BUILDING CODE OF AUSTRALIA ASSESSMENT REPORT

Project: UTS Peter Johnson
Client: Hutchinson Builders

Revision History:
Report: 29602/290304

Level 5 - Podium Level
 1:200 @ A1, 1:400 @ A3
 20th March 2009
 3531_DA007

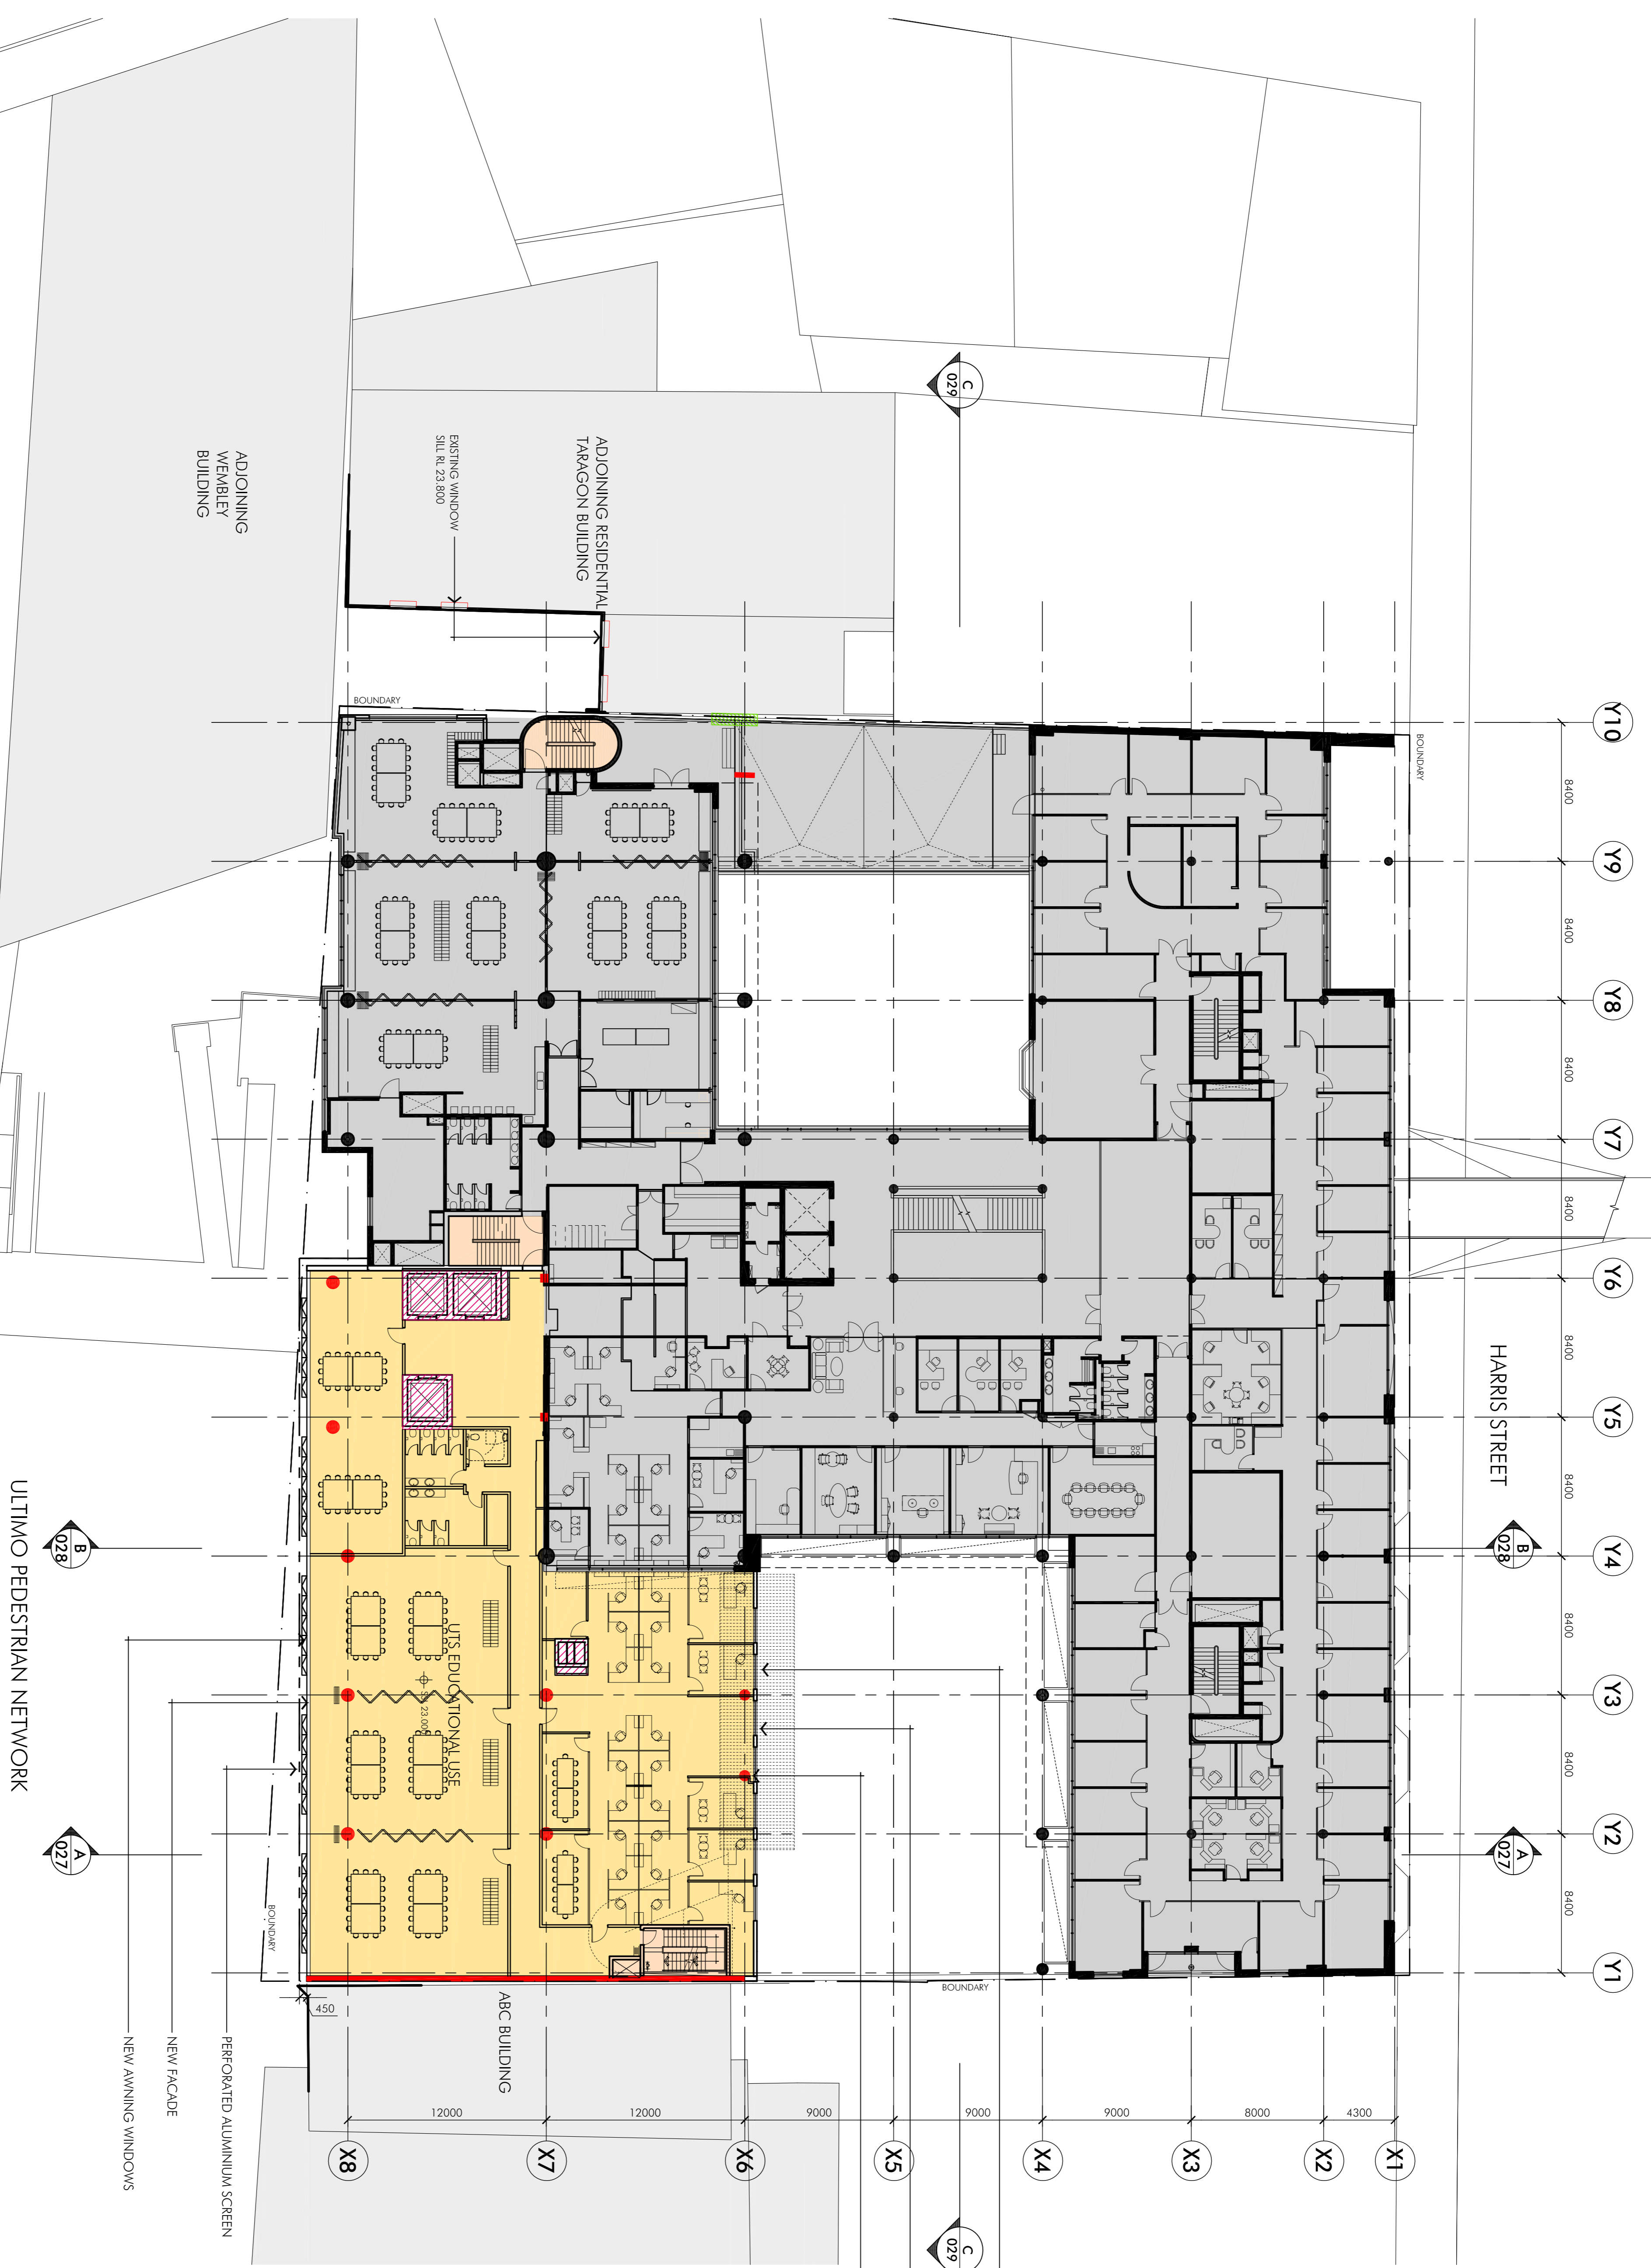
C1.1,
Clause 3.5 | The roof is not required to have an FRL if its covering is non-combustible and a sprinkler system is installed throughout the building. The roof over the roof terrace area is proposed to be metal clad and the existing portion of the building does not contain a sprinkler system throughout. |
